Planning Application, R/243/17/HH, for No. 9 Park Drive, Rustington

Rustington Parish Council has recently made me aware of the above planning application which relates to my neighbouring property

Project:
Description
Proposed First Floor Plan

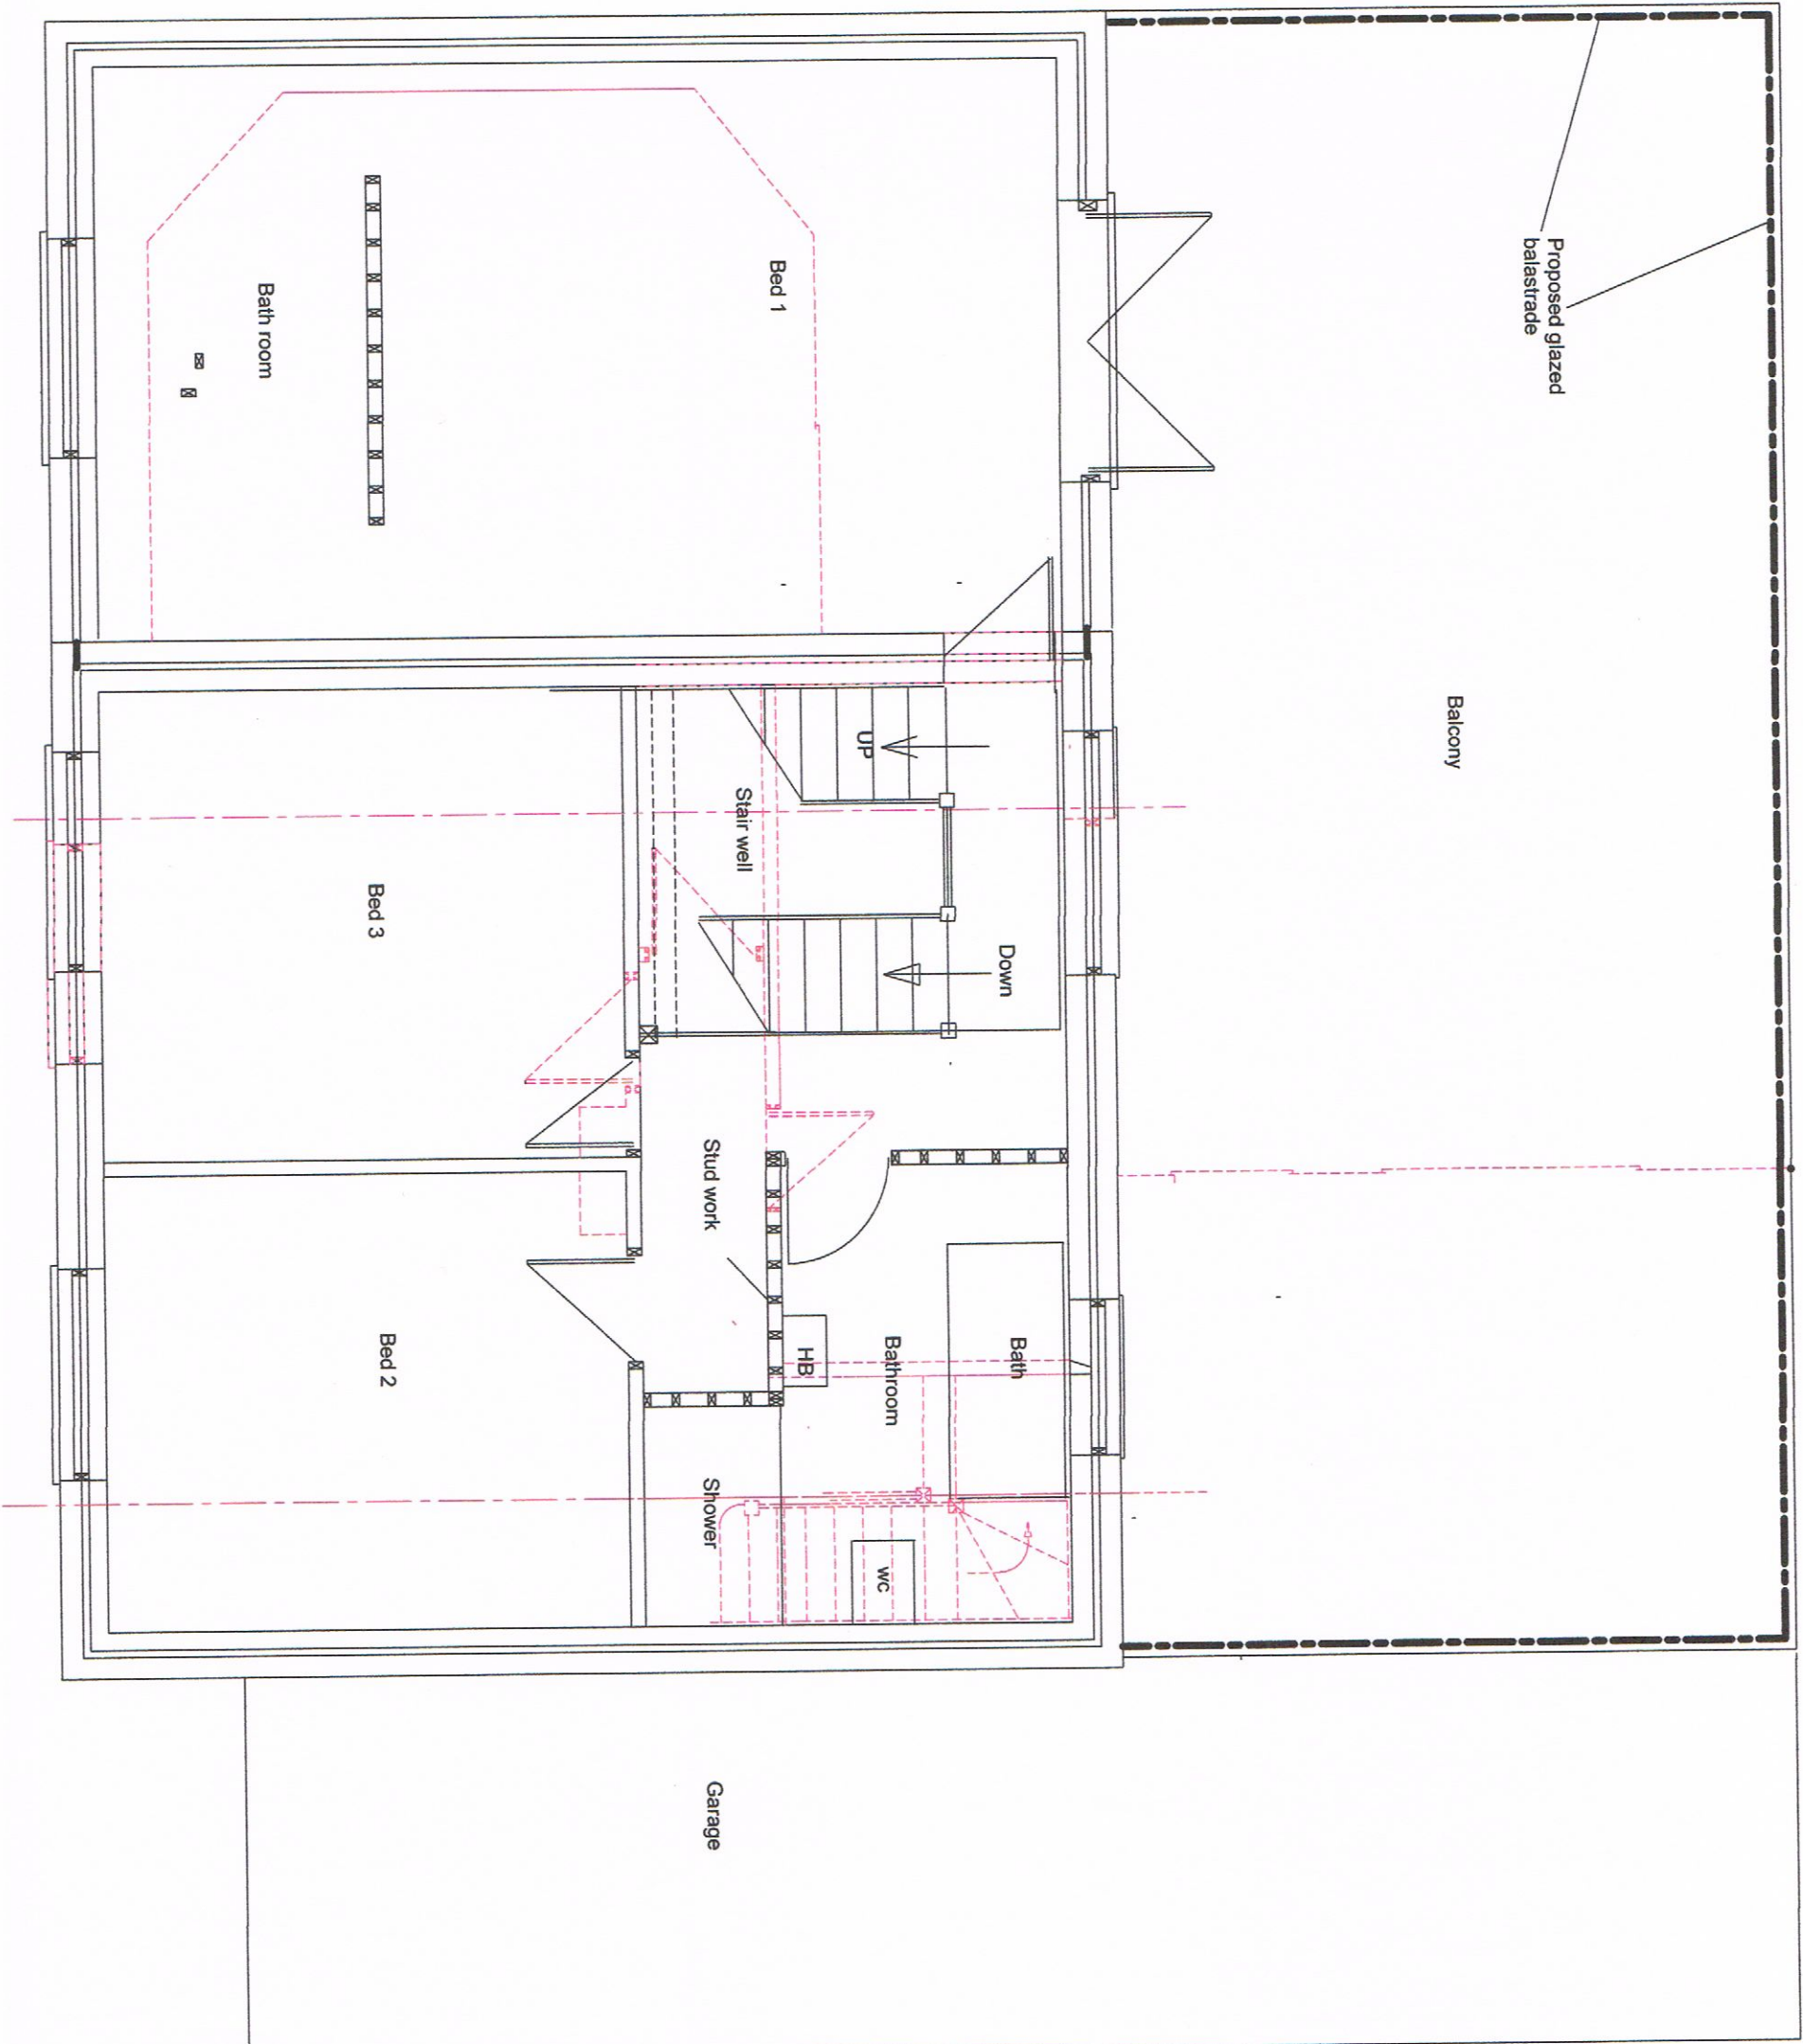
A cursory inspection of the plans makes it clear that the proposed balcony at the rear of the building would result in my rear garden being overlooked, leading to a distinct lack of privacy

Project:
Description
Proposed Ground Floor Plan

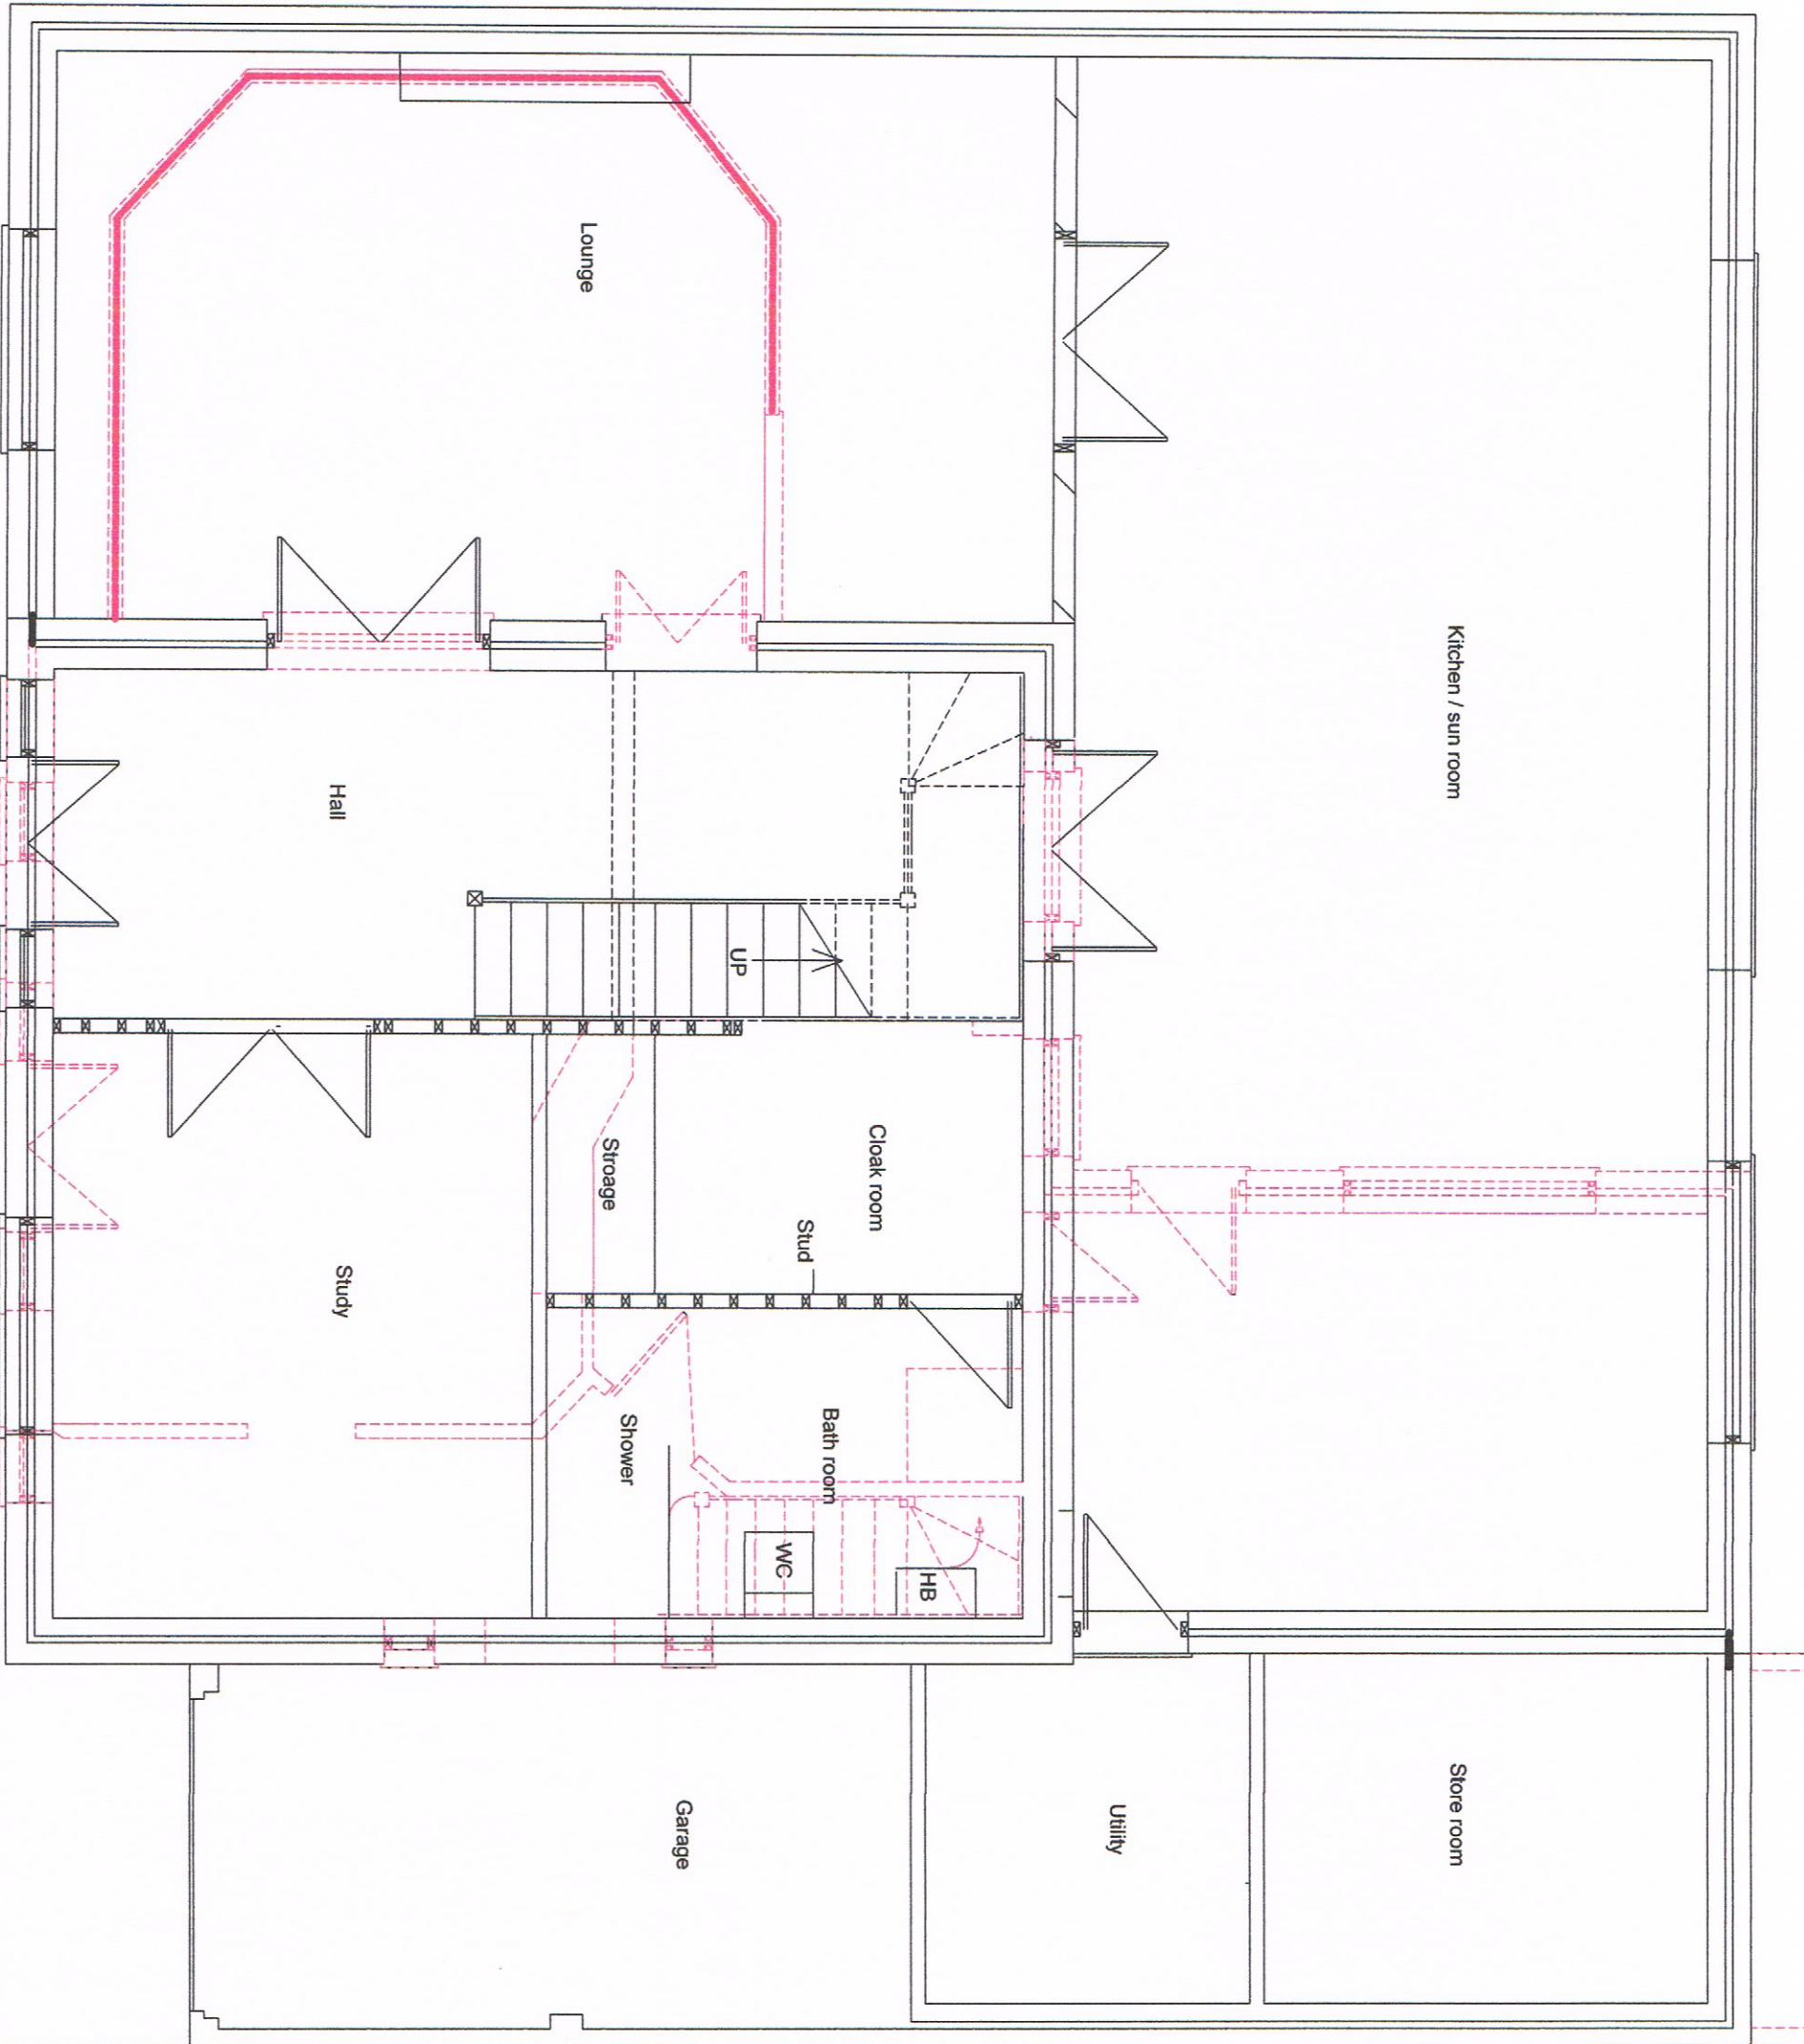
This latter problem is exacerbated by the fact that a development on this scale, which amounts to an almost doubling of building's footprint, is totally unacceptable on a plot of this size. As one can see, it has resulted in a proposal to construct an extremely tall edifice extending to the site boundary

Proposed roof plan Plan
Scale 1:50 Paper Size A3

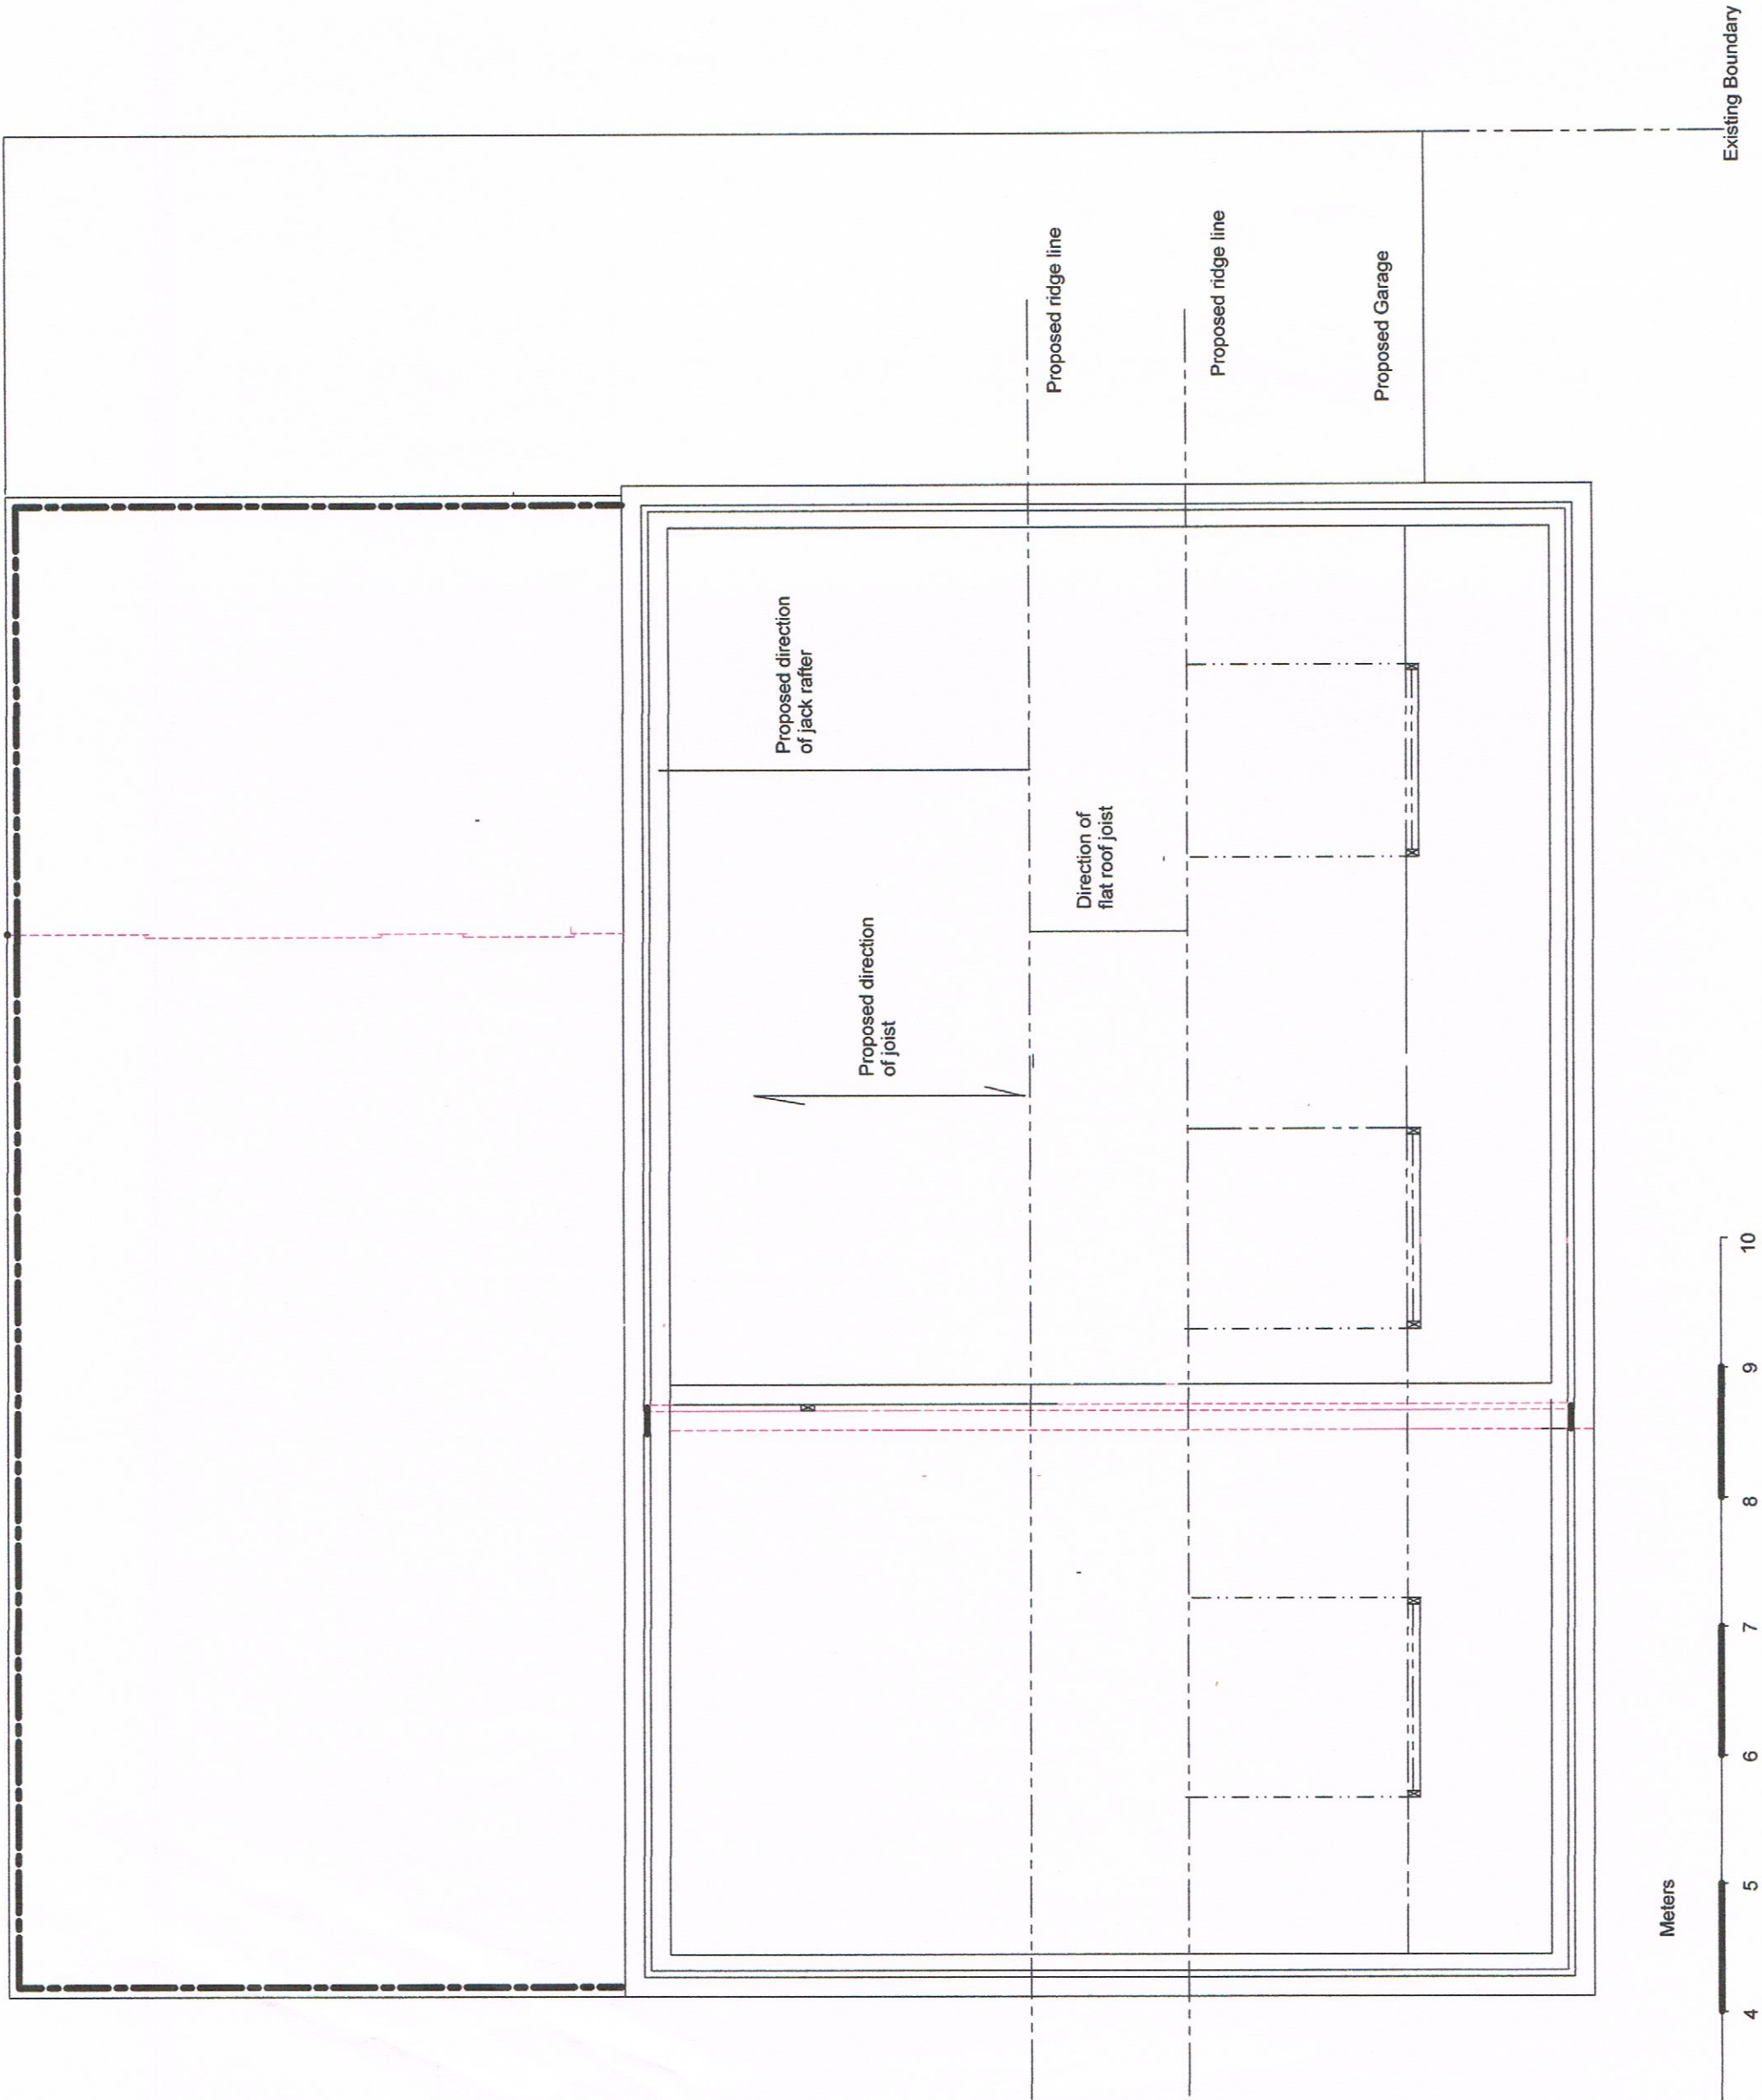
Further, the huge size of the intended development and both the increase in height and extension of the roofline would seriously reduce the amount of daylight and sunlight, I currently enjoy
